Dogger Bank South Offshore Wind Farms

**Appendix 29-1 Tourism and Recreation Consultation
Responses**

Application Reference: 7.29.29.1

Table 29-1-1 Consultation Responses Related to **Volume 7, Chapter 29 Tourism and Recreation (application ref: 7.29)**

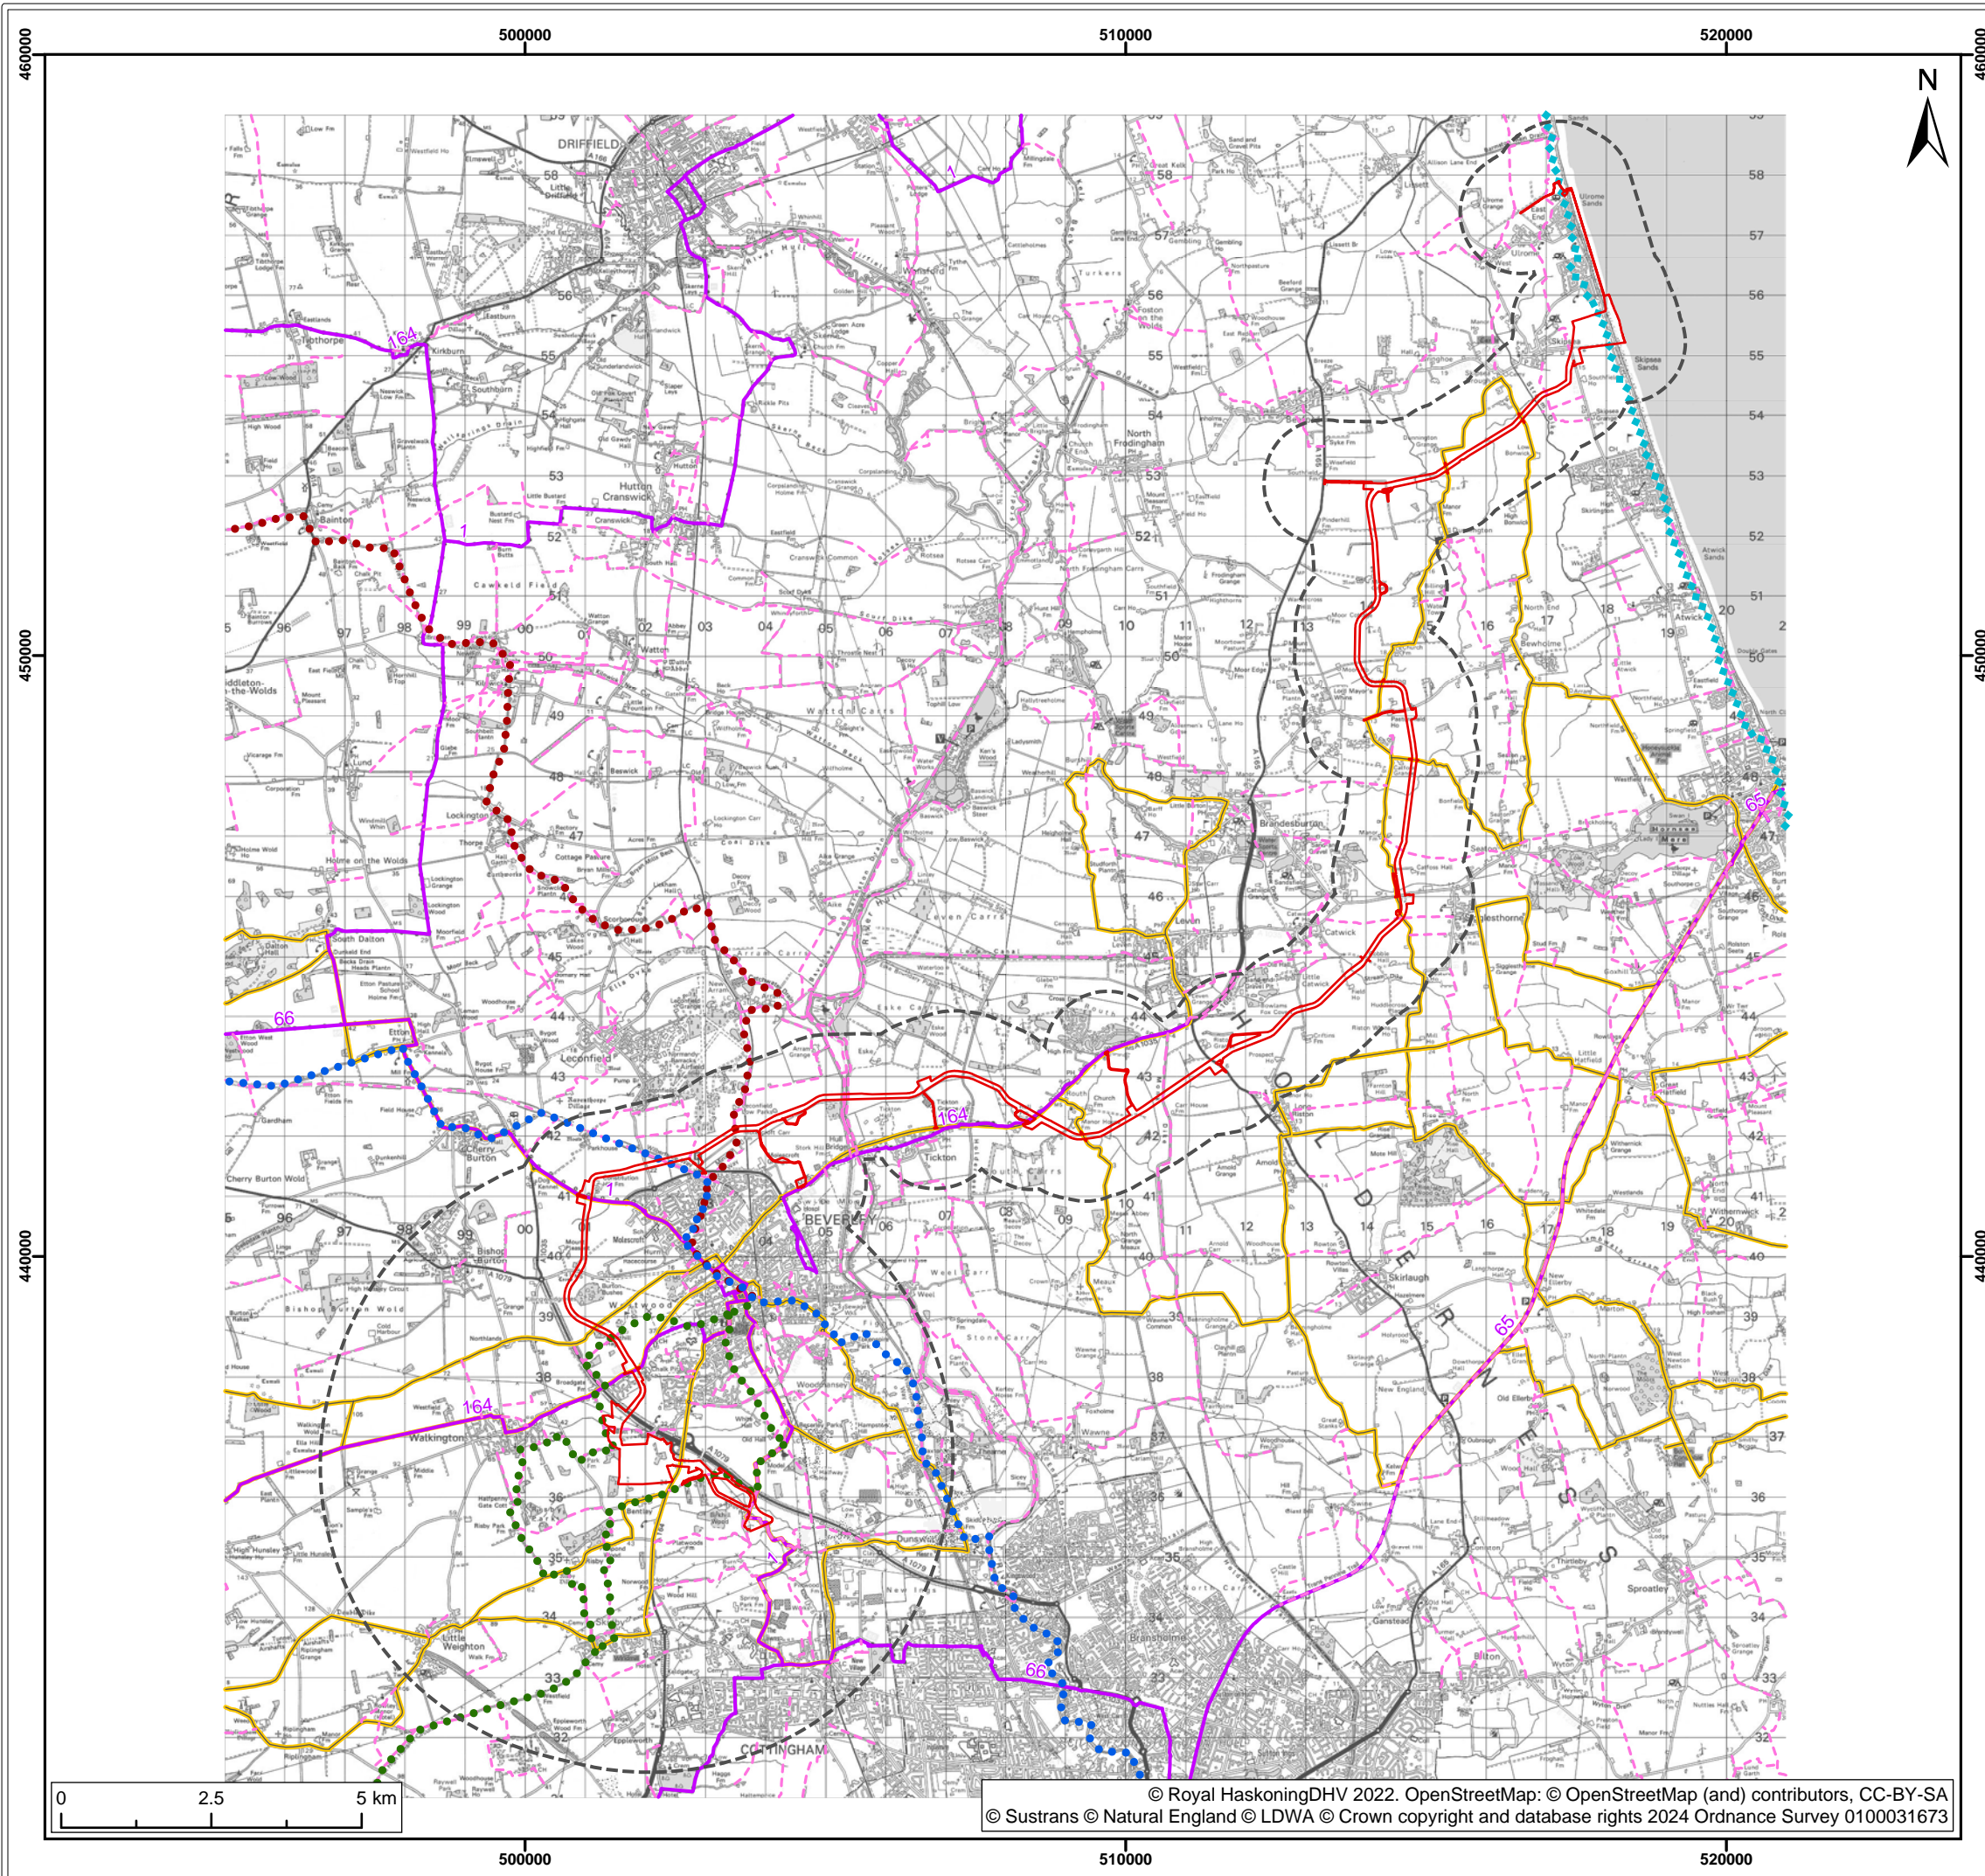
Comment	Project Response
into consideration sensitivity and magnitude of the impact of the Projects.	considered within the assessment of effects on tourism and recreation (section 29.6).
Section 42 Consultation - Beverley Ramblers - Ramblers Association July 2023	
The Minster Way foot path to the North of Beverley would be adversely affected by the scheme, if the cable route were to the North of Beverley.	The Minster Way is considered as part of the Volume 7, Chapter 29 Tourism and Recreation (application ref: 7.29) baseline (section 29.5.6) and within the assessment of effects on tourism and recreation (section 29.6). Any potential impacts from works relating to the Onshore Export Cable Corridor will be temporary, with any affected land being re-instated following construction works concluding.
Section 42 Consultation - Haven Leisure July 2023	
The assessment of effects on tourism and recreation during the construction period shows a minor adverse and insignificant impact. There is also no specific reference to Far Grange (and all its operations) as a receptor within the PEIR and this needs to be re-examined.	Far Grange Holiday Park is included in the Volume 7, Chapter 29 Tourism and Recreation (application ref: 7.29) baseline (section 29.5.7) and within the assessment of effects on tourism and recreation (section 29.6).
